App: F/22/21/PL

Proposal: 23 No dwellings with associated access, infrastructure, landscape and open space (resubmission following F/5/21/PL). This application is a Departure from the Development Plan & is in CIL Zone 3 and is CIL Liable as new dwellings.

Address: Land rear of Paynters Croft Burndell Road Yapton BN18 0HR

Figure 5. Features to enhance / mitigate for impacts to bats designed into the scheme.

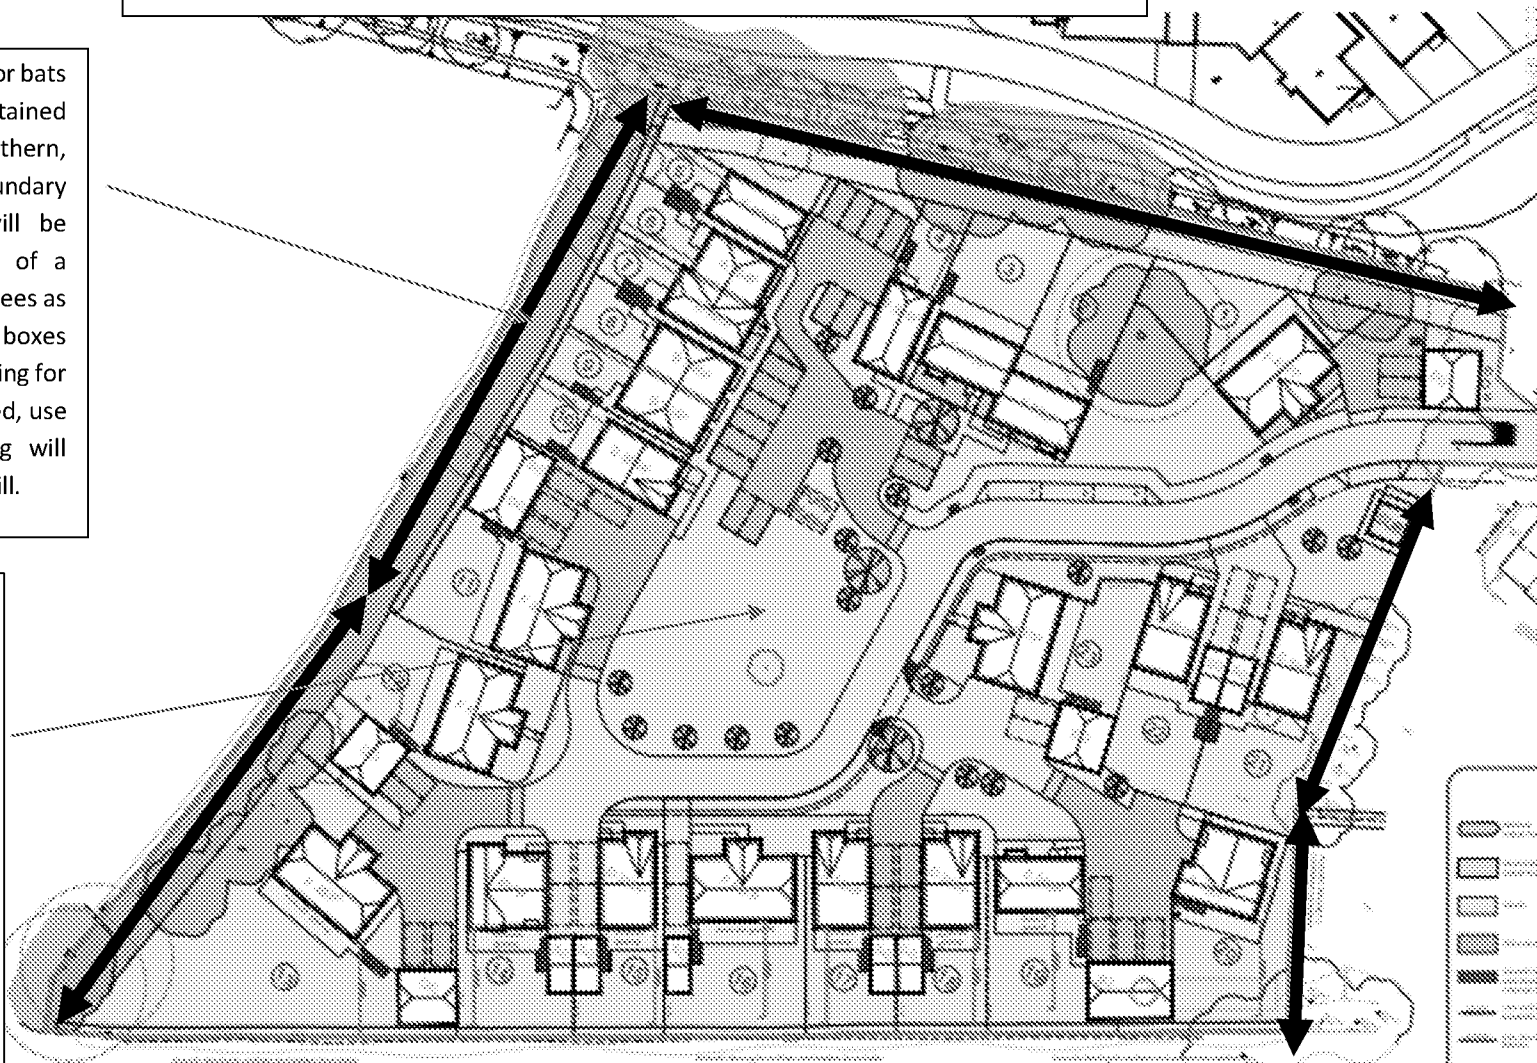
Lighting

The lighting scheme for the site will need to take into consideration the presence of bats in the local area and the scheme should minimise potential impacts to any bats using the trees, hedgerows and buildings by avoiding unnecessary artificial light spill through the use of directional light sources and shielding.

We would ask that the applicant provide information to satisfy us that the complies with the guidelines outlined in the new Bats and Lighting Publication produced by the Institution of Lighting Professionals and the Bat Conservation Trust "Guidance Note 08/18 Bats and artificial lighting in the UK Bats and the Built Environment series publication should be adopted into the site plans (http://www.bats.org.uk/news.php/406/new_guidance_on_bats_and_lighting).

As per the, the hedgerows on site are used by bats for commuting and foraging and will need to be retained and enhanced for bats. This will include having a buffer strip around the hedgerows (5m) and during construction fencing should be used to ensure this area is undisturbed. Any gaps should also be filled in using native hedge species to improve connectivity.
